Sent: 07 October 2013 18:05
To: Planning
Subject: Welwyn Hatfield Council Online Planning - Comment

Application Number: N6/2013/1938/MA
Name: Peter Adderley
Address: 30 Templewood
Welwyn Garden City
AL8 7HX
Comment Type: Object
Comment: ARCHITECTURE

Title Proposed Materials

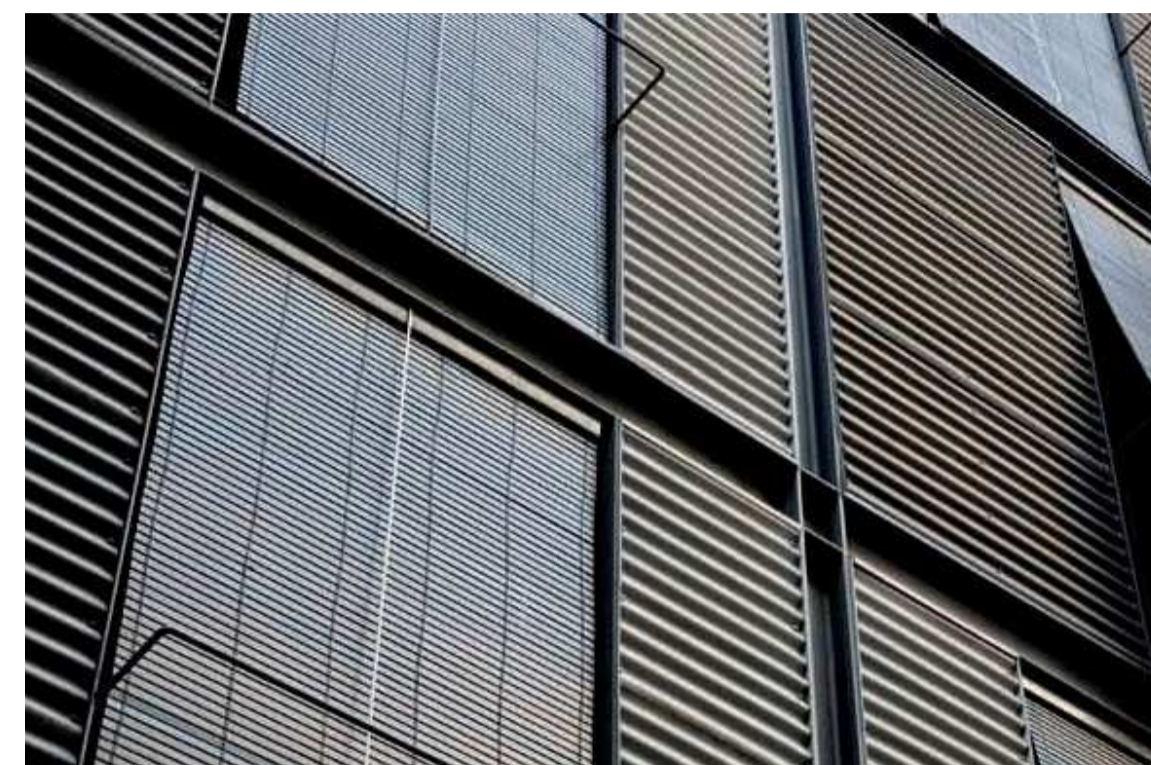
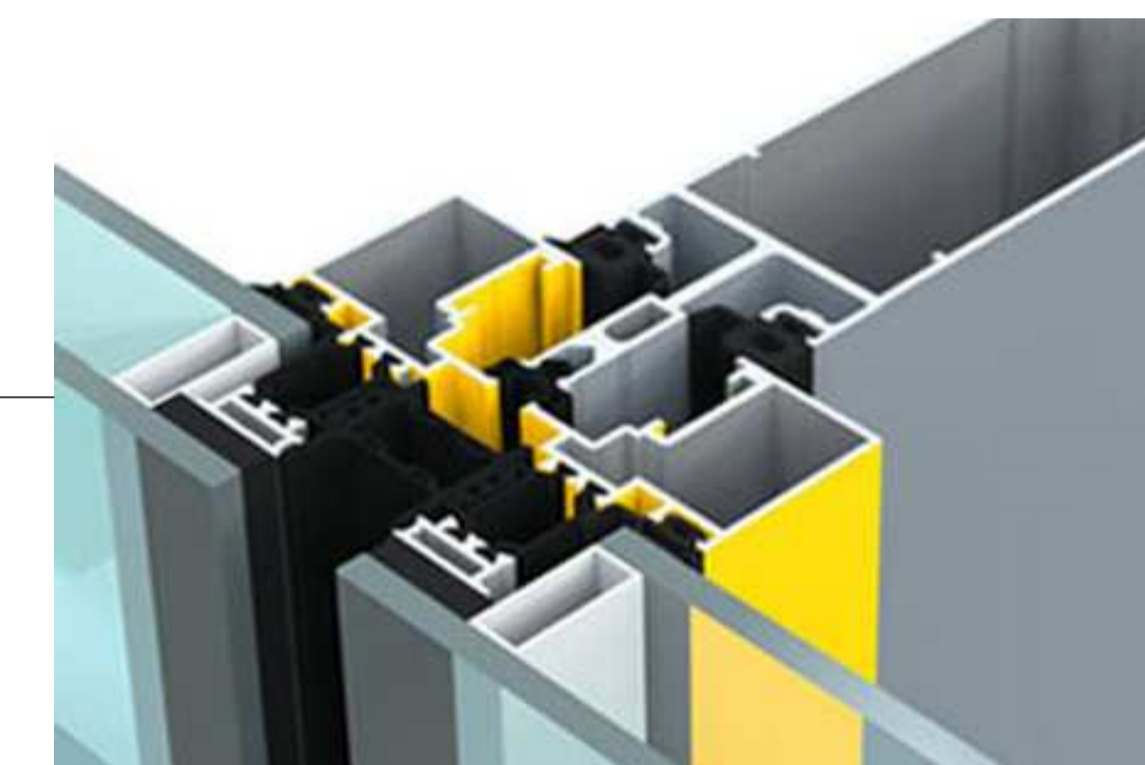
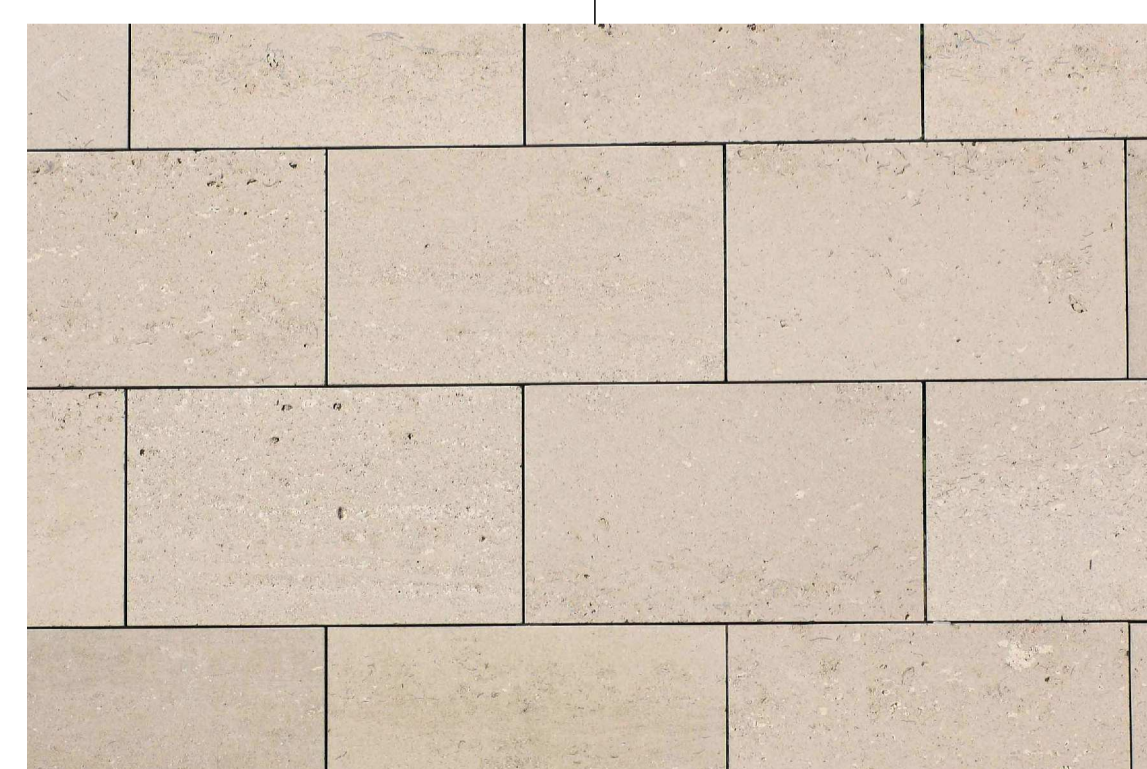
1. The proposed architectural treatment is quite unacceptable - brutal and out of keeping with the existing buildings.
2. There is no objection to a glazed wall in itself; the device is often used as a non-obtrusive link between new and old buildings (including the Campus elevations of the old and new council office buildings on this very site). Instead of RPS's over-large glass block, I can envisage a full-width two-storey screen linking the two wings with a third storey set back beyond. But it would have to be very sensitively designed, not crudely like this.

4. The report claims that matching bricks are unobtainable. This may be true, but there is a very wide range of bricks available, and something suitable - blending or contrasting - could surely be found.
